Your ref:  
Our ref: 21/00758/F  
Please ask for: Miss Sandra Homcenko  
Direct dial: 01553 616824  
Direct fax: 01553 616652  
E-mail: borough.planning@west-norfolk.gov.uk

20 April 2021

Details: **Proposed Single Storey One Bedroom Aneexe. at 50 Fitton Road Wiggshall St Germans King's Lynn Norfolk PE34 3AX**

Drawing Title : Proposed Partial Ground Floor and Garden Plan

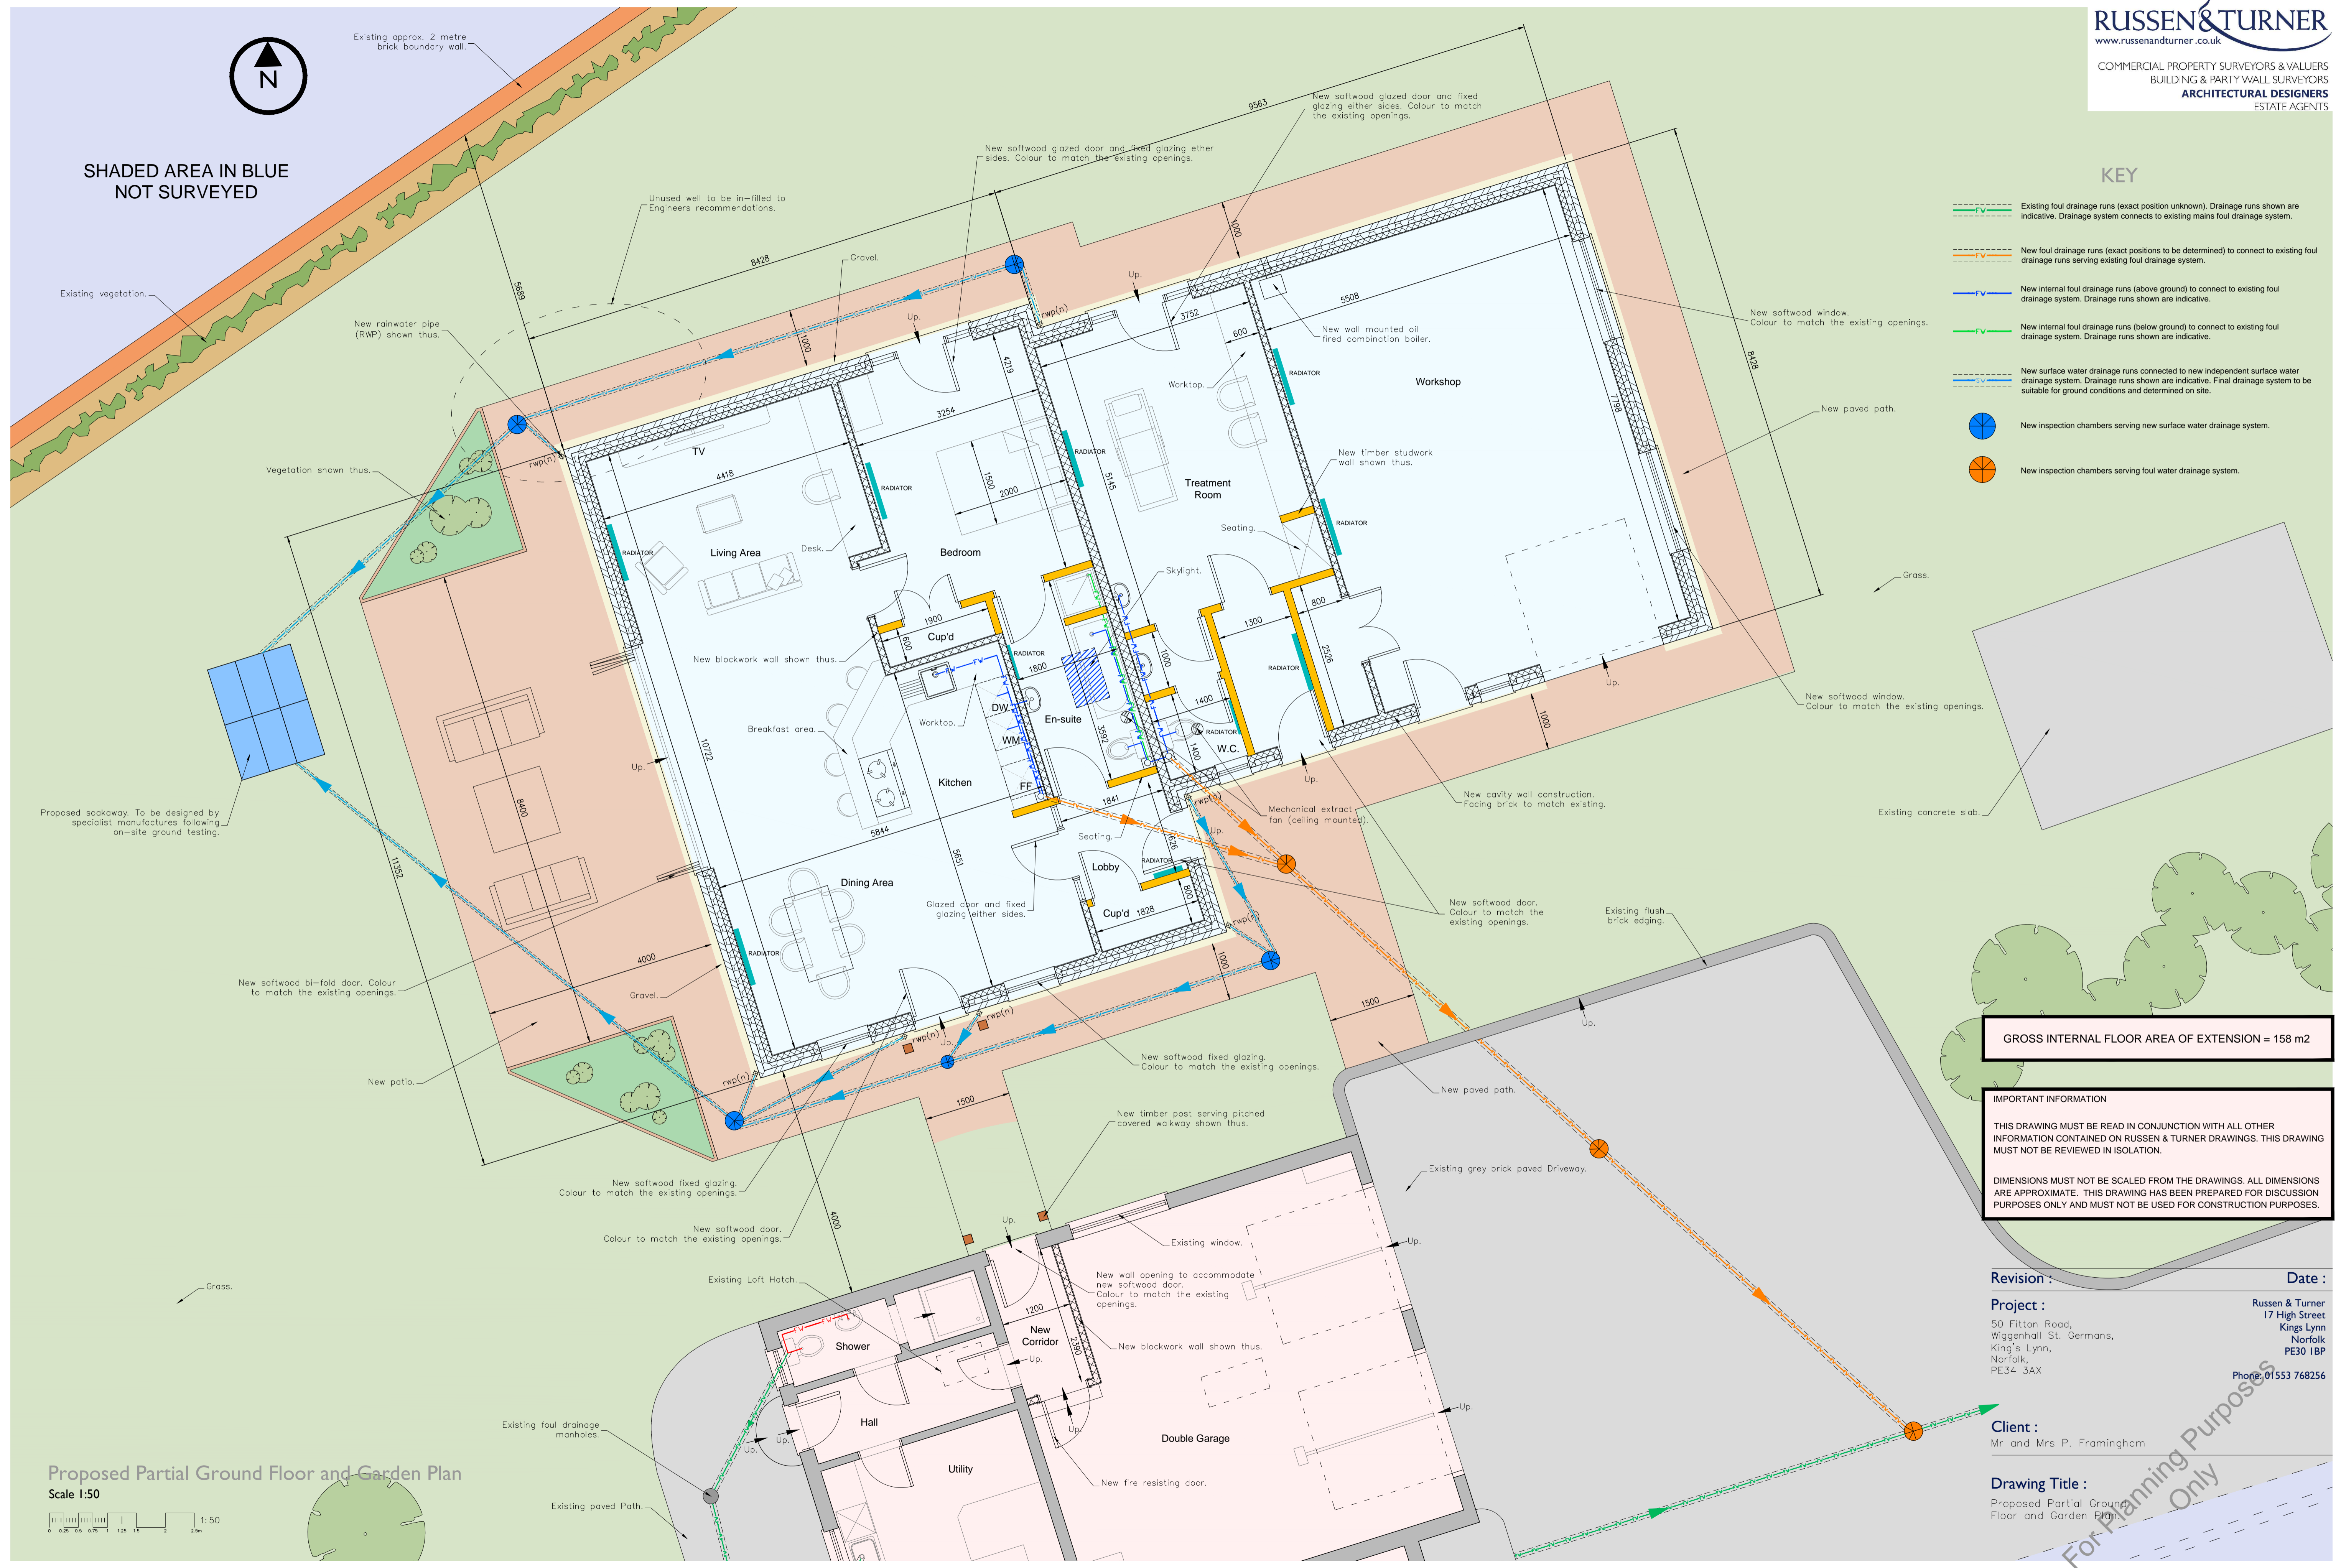
1. As you have supplied partial Floor plans for an existing dwelling, we were unable to compare the floor space for existing dwelling and proposed annex, therefore please confirm if the proposed Annex meets the following:
  - (1) Ancillary to the main dwelling
  - (2) Within the curtilage of the main dwelling
  - (3) Share the same garden
  - (4) Share the same access
  - (5) Share the same parking
  - (6) Should be smaller than the main dwelling
